PLANNING AMENDMENT

REFRIGERATED STORE QUADRING BANK, QUADRING, Lincs.

H15/0703/95

EXCLUSION & HYSTANDING TO
EXTG. STEEL AGRICULTURAL
BUILDINGS.

GENERAL SITE LAYOUT.

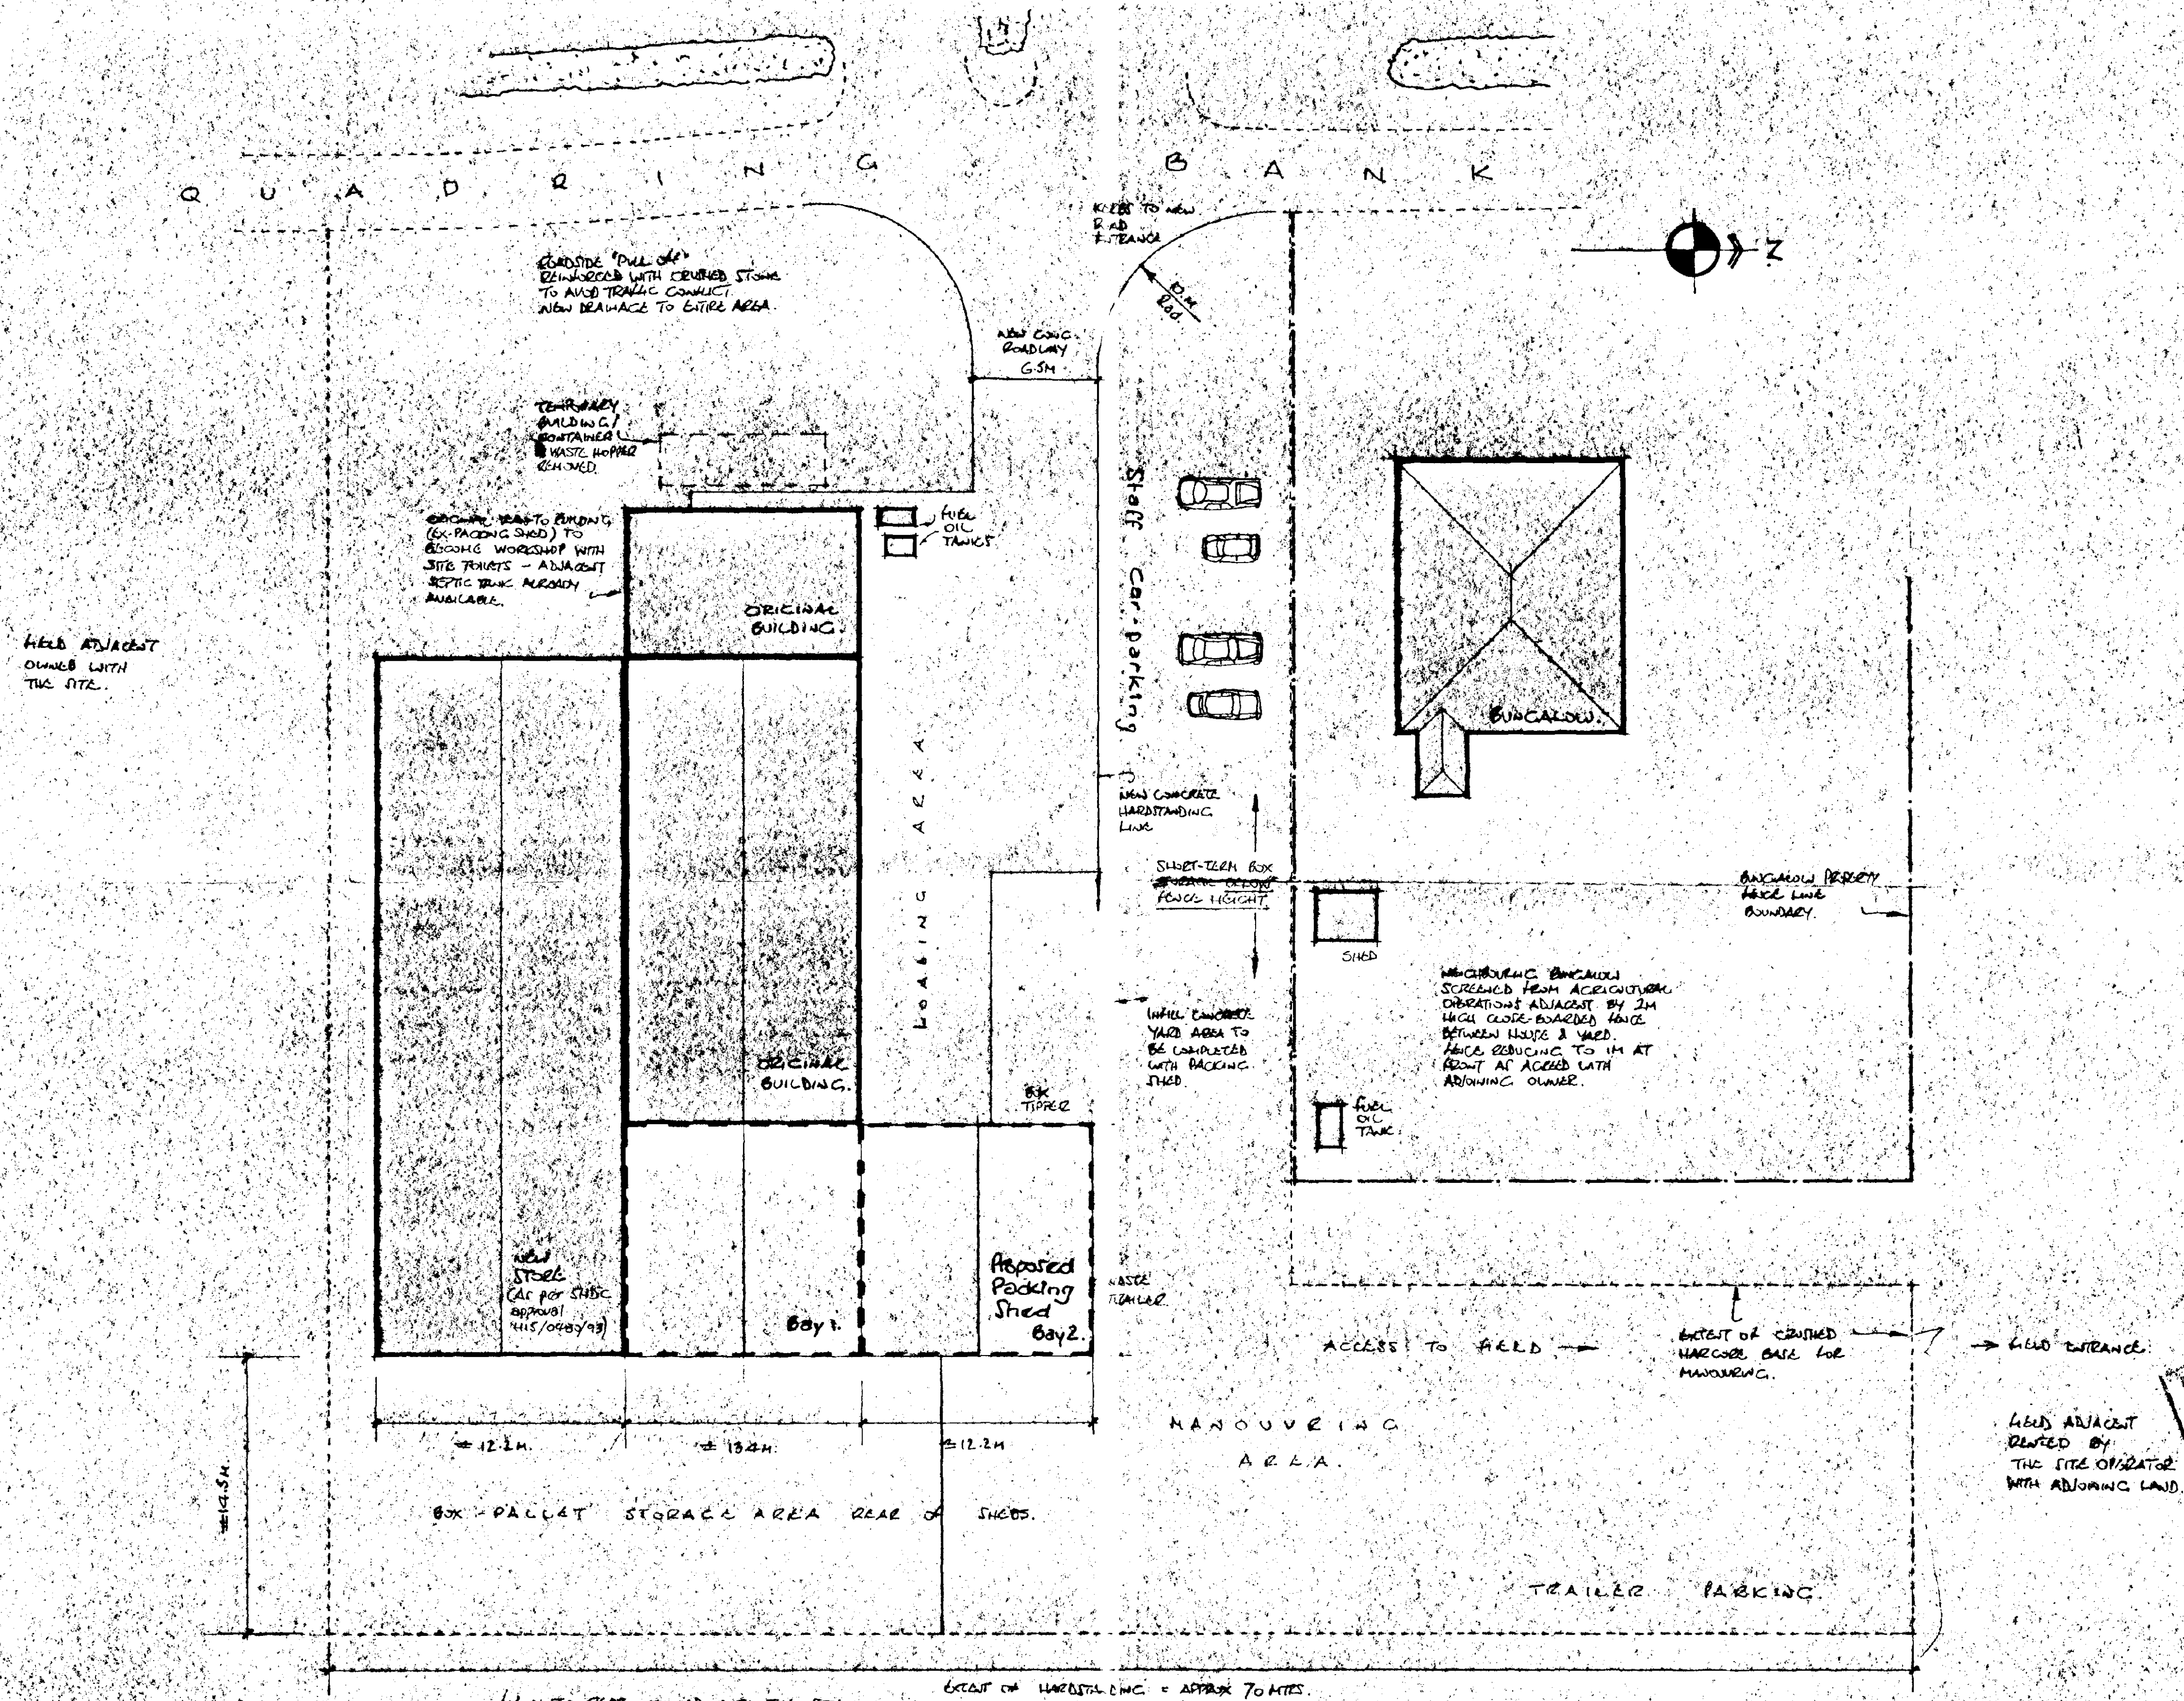
USAGE OF AREAS NOTED
ON SITE PLAN. (SP1/7/95
ONLY)
